Re: The M12 Motorway (SSI-9364) – Submission on Environmental Impact Statement

Council welcomes the opportunity to provide comments on the Environmental Impact Statement (EIS) for the proposed M12 Motorway between The Northern Road and the M7 Motorway. A portion of the project is in the Liverpool Local Government Area (LGA).

Figure 1-2 Key features of the project

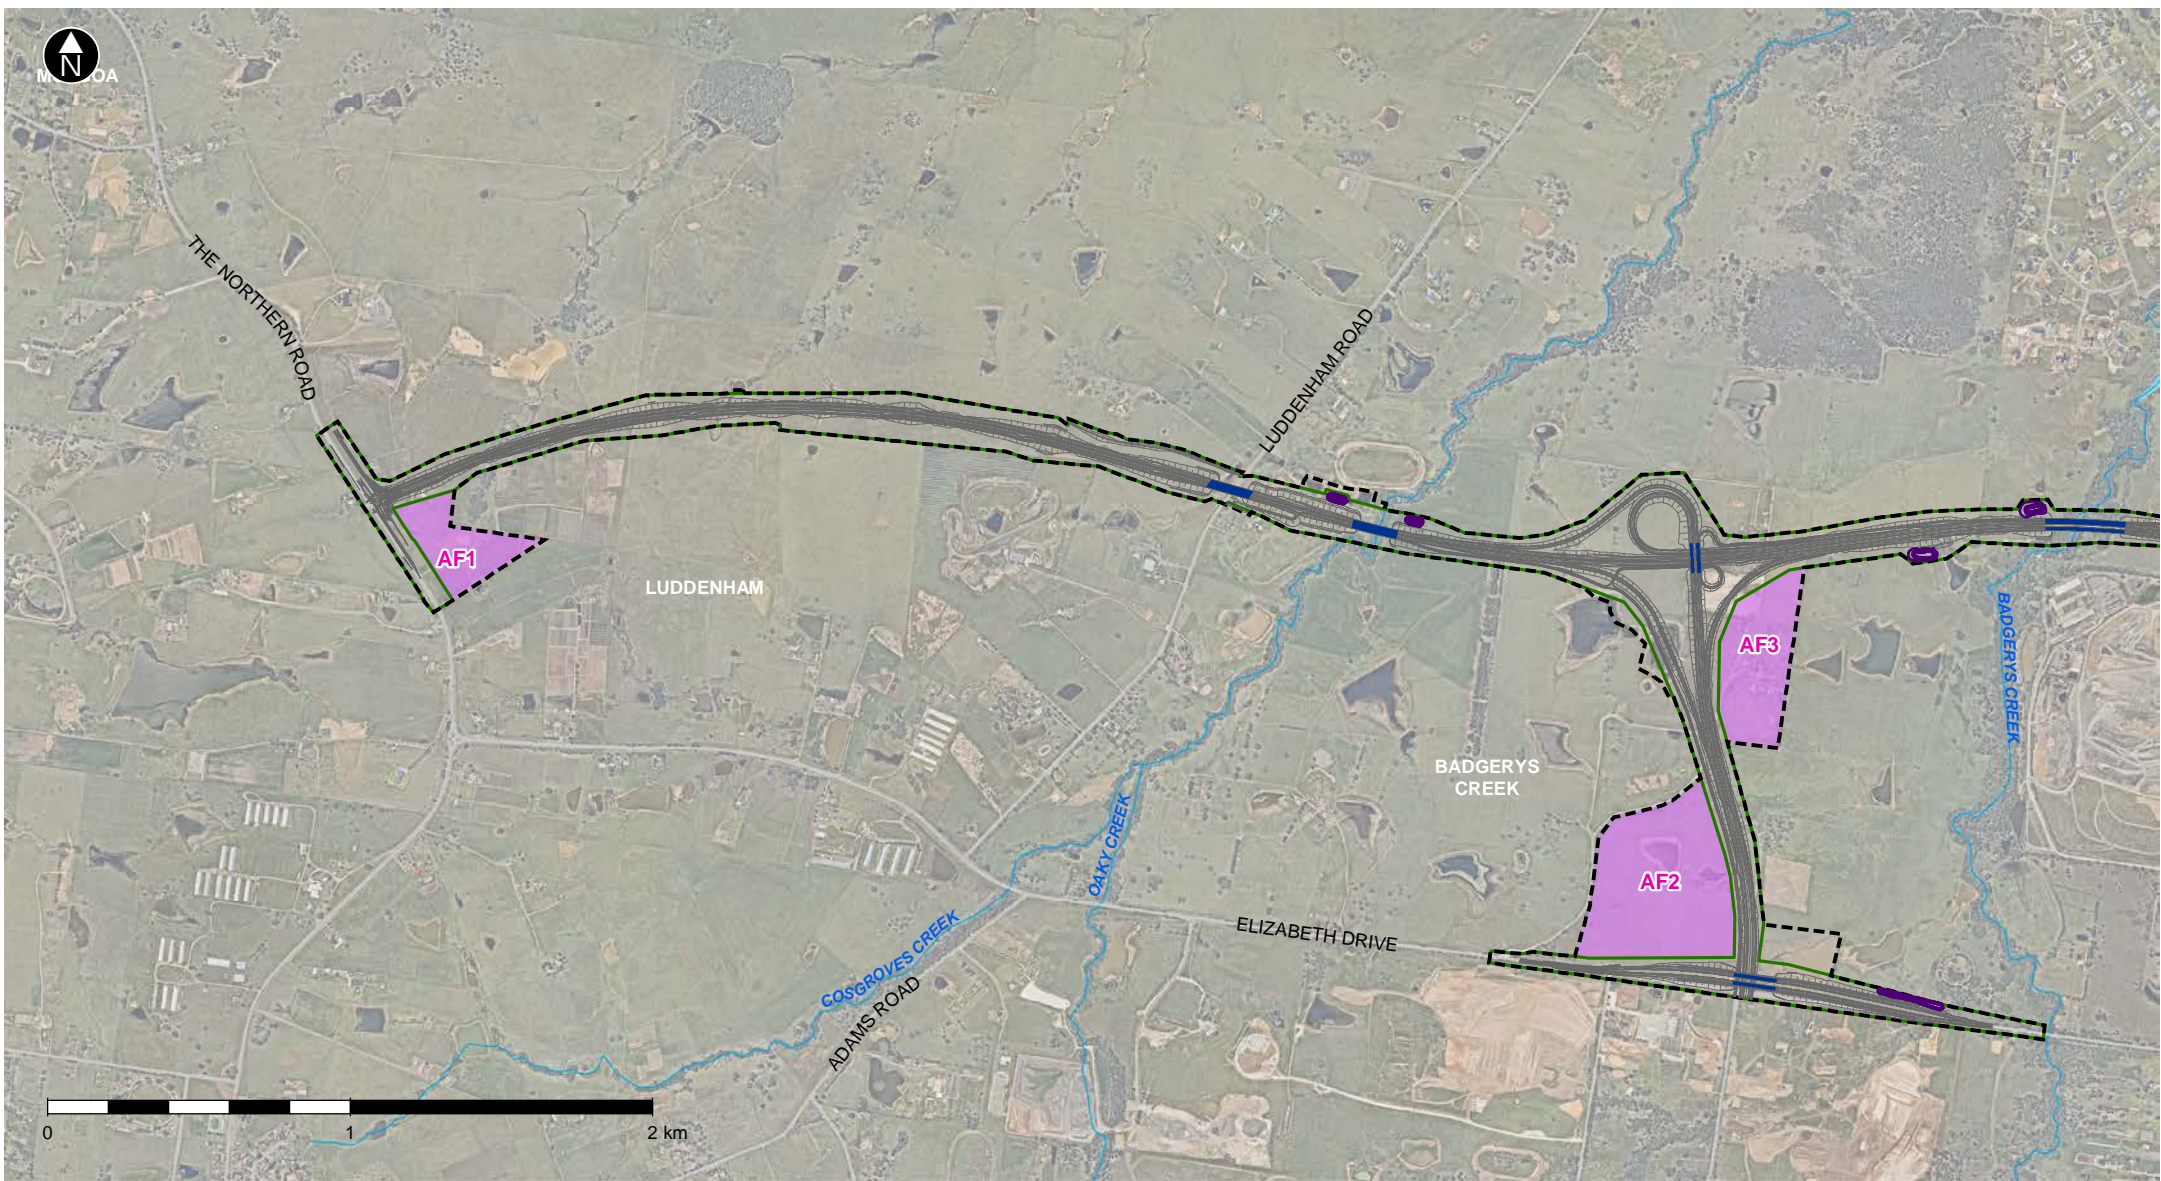
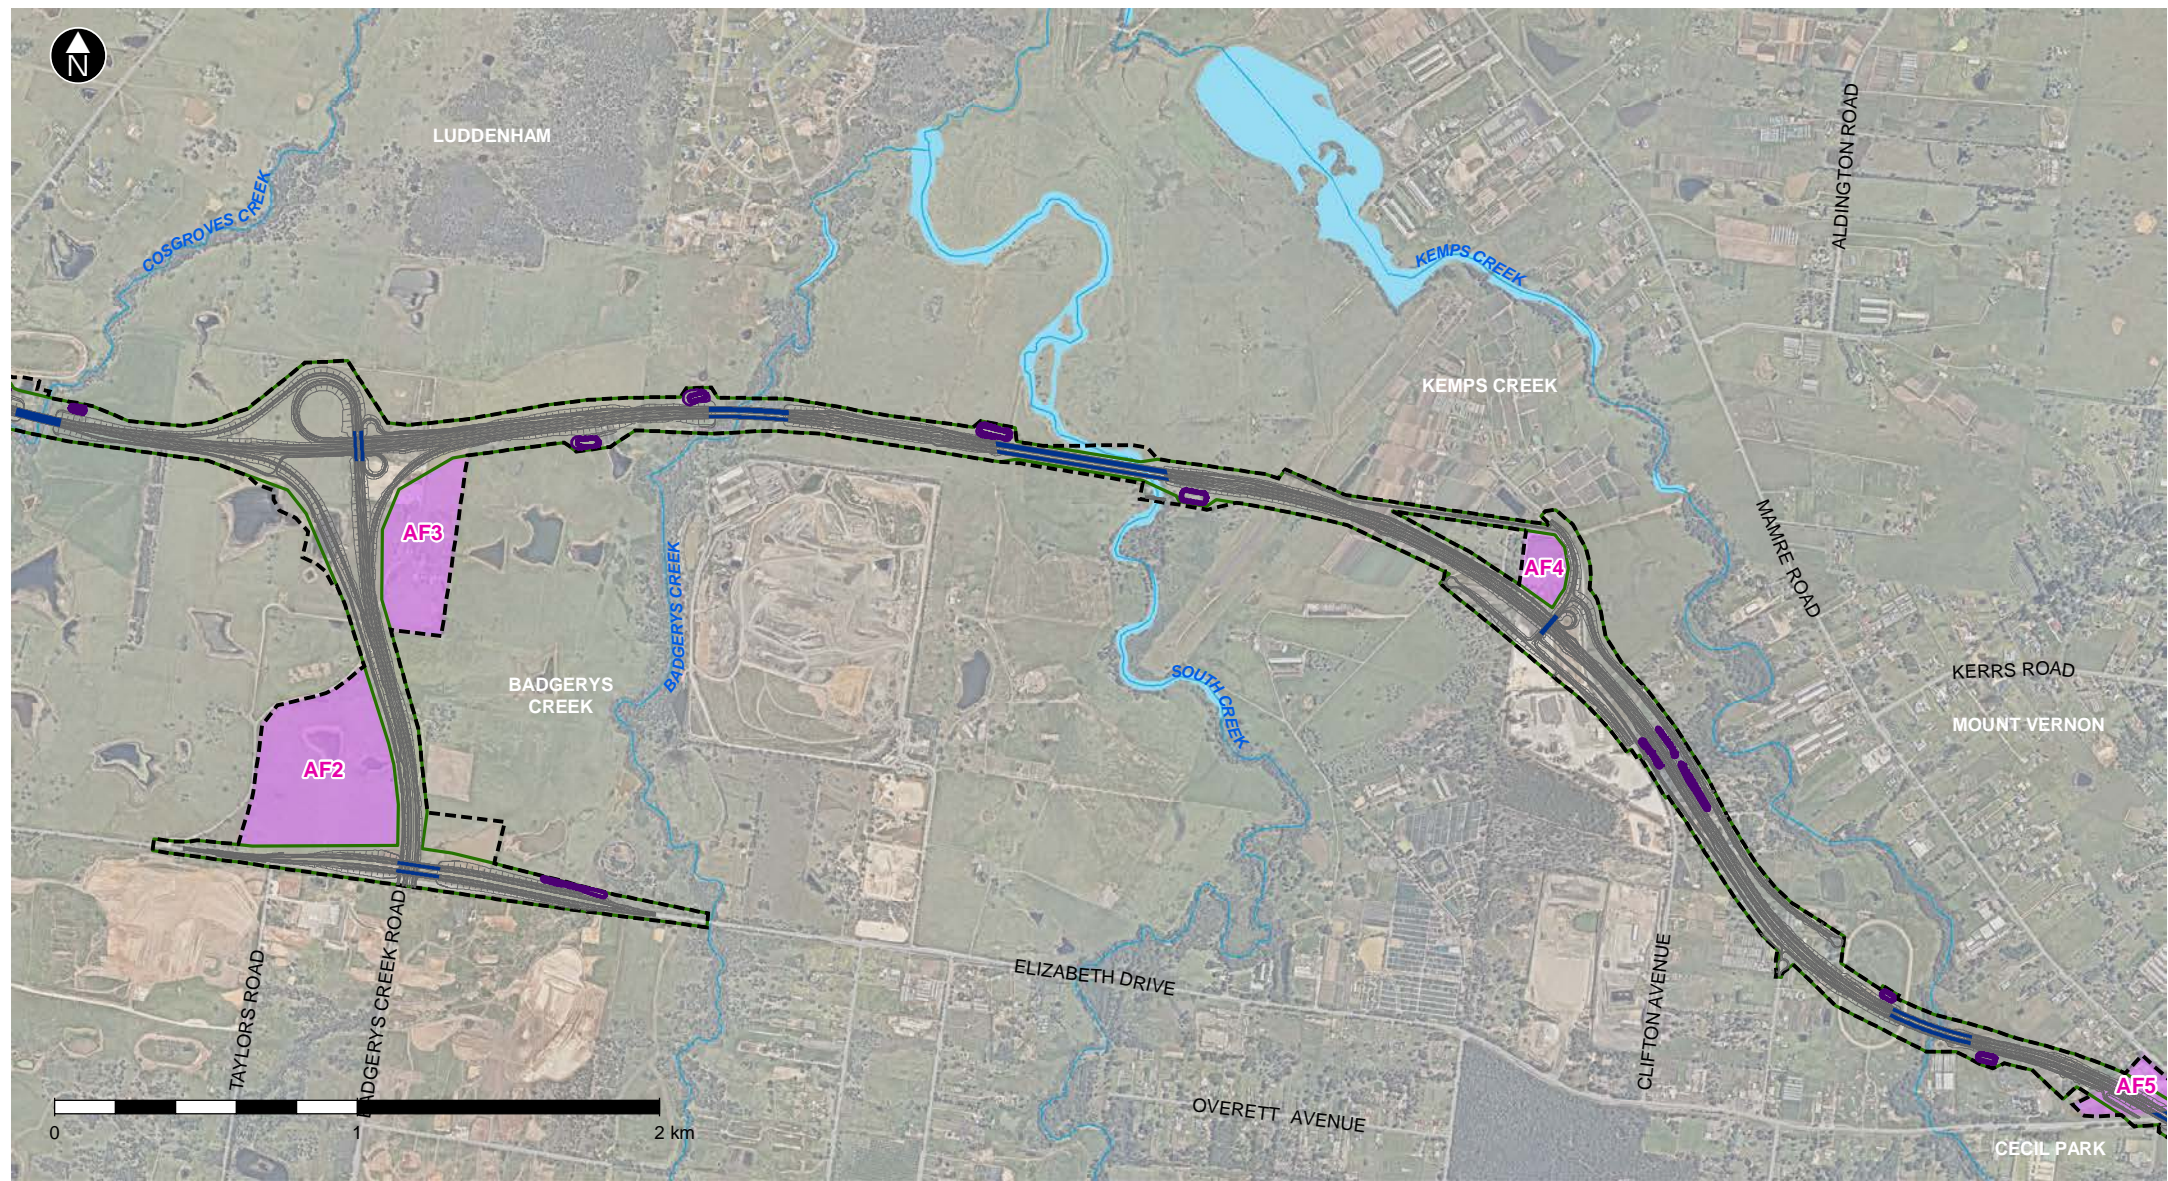
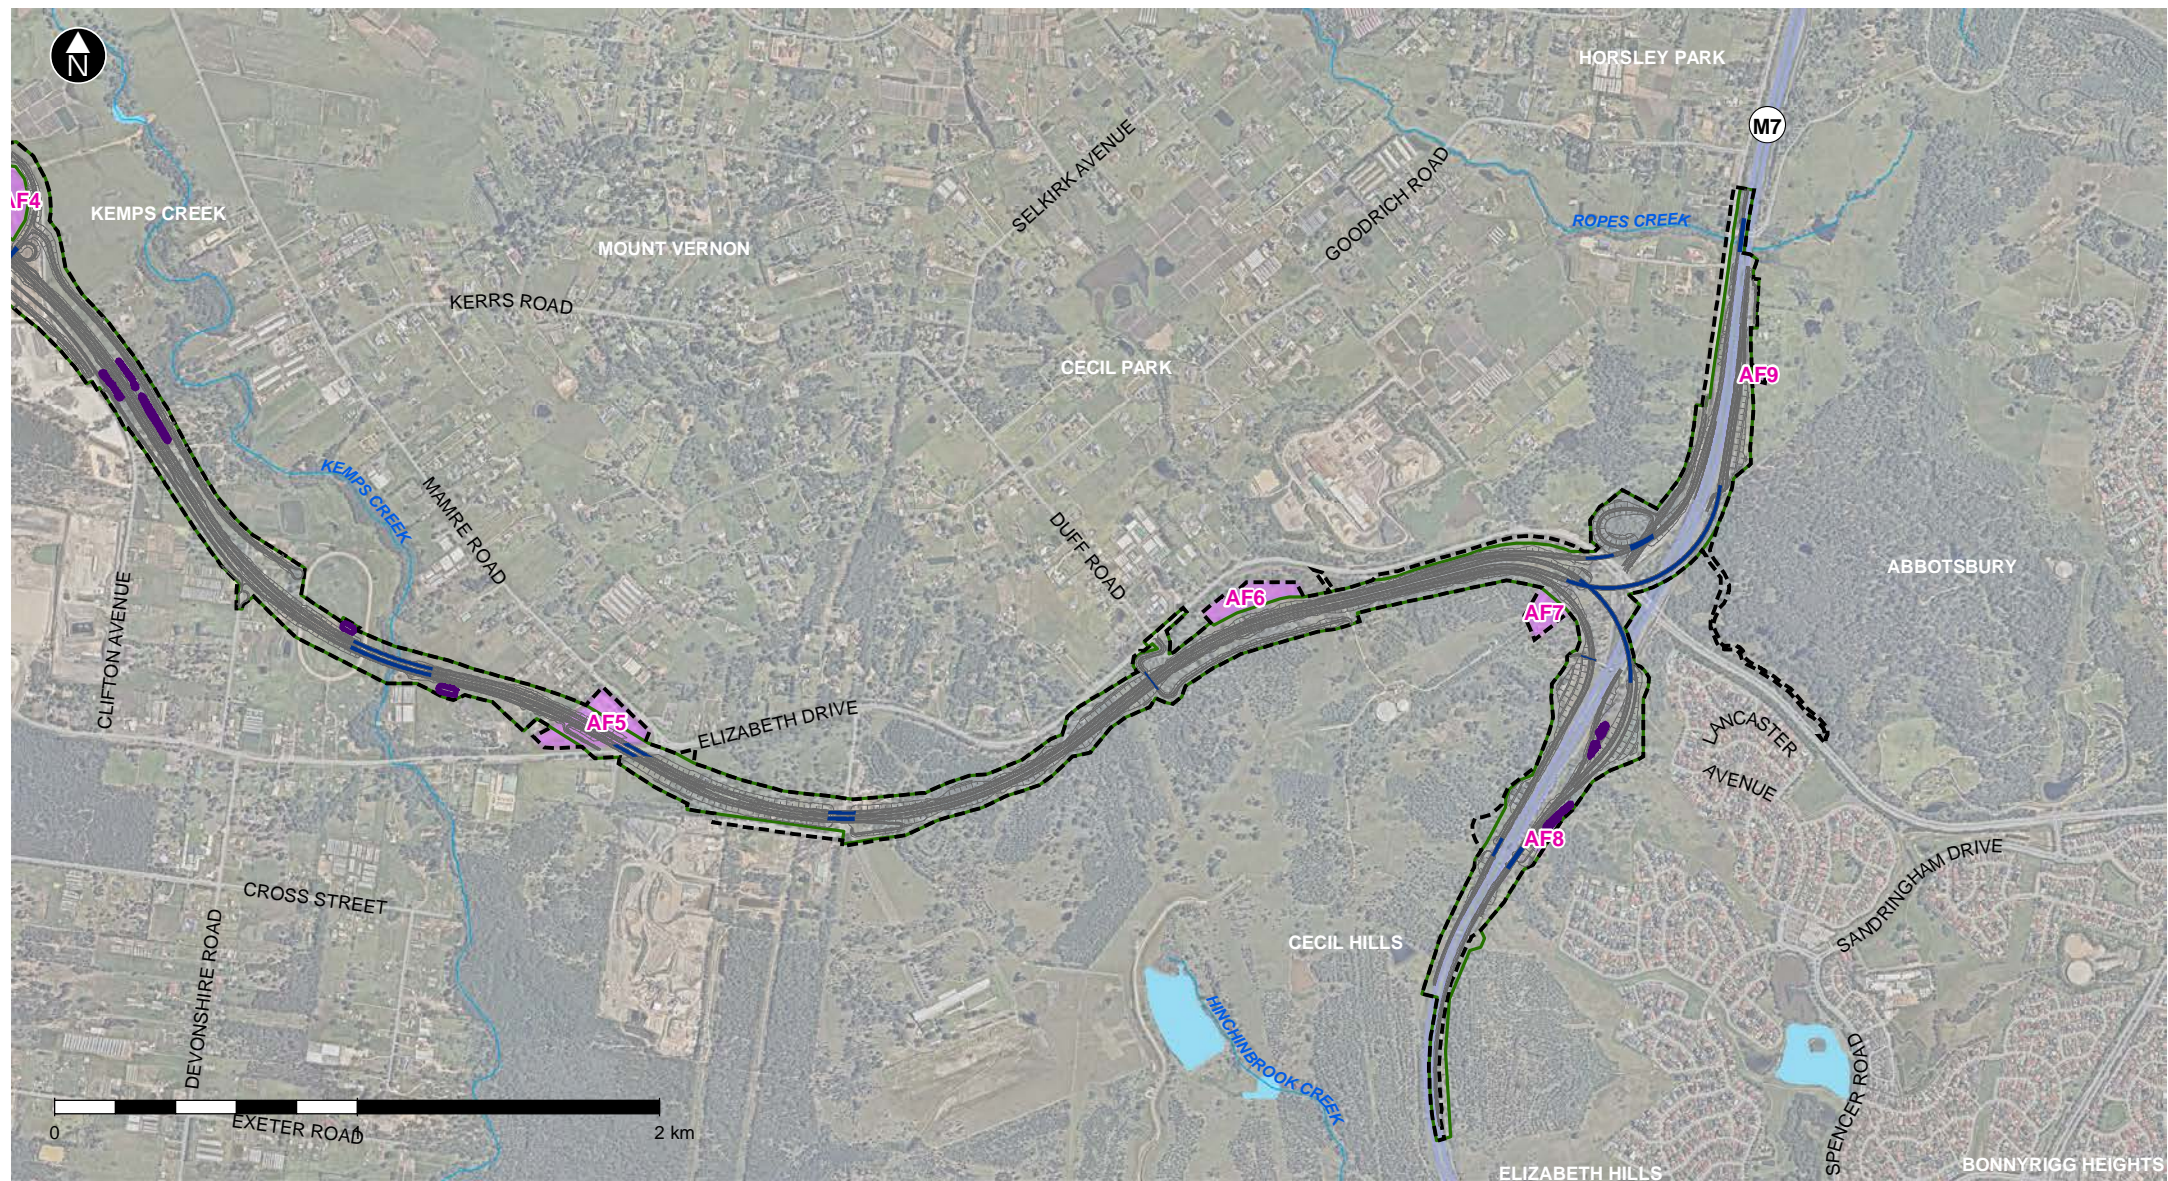
Council supports the project as part of the WSIA ground transport infrastructure. However, Council is very concerned that the proposed motorway does not include a direct connection to Elizabeth Drive. The current design indicates that the proposed motorway would have limited access to the surrounding areas, including:

An interchange with Elizabeth Drive is essential as are on-ramp and exit off-ramps at Elizabeth Drive. If these on/off-ramps are not provided, the forecast growth in these areas will have an unacceptable impact on Elizabeth Drive (which will require road widening in the medium term).

Council's preferred location for an interchange is where the proposed motorway, Elizabeth Drive/Mamre Road/Devonshire Road meet. If this is not possible, Elizabeth Drive must be upgraded to serve the planned industrial developments and business parks in the WSIA and the surrounding areas.

Council is concerned that the southern off-ramp from the proposed M12 Motorway onto the M7 Motorway within Western Sydney Parklands (WSP) will be close to the Cecil Hills residential area. This is likely to have visual and noise impacts on the residential area.

It is recommended that the off-ramp is moved as far as possible away from the residential area and must include appropriate noise and landscaping mitigation measures to limit these impacts.
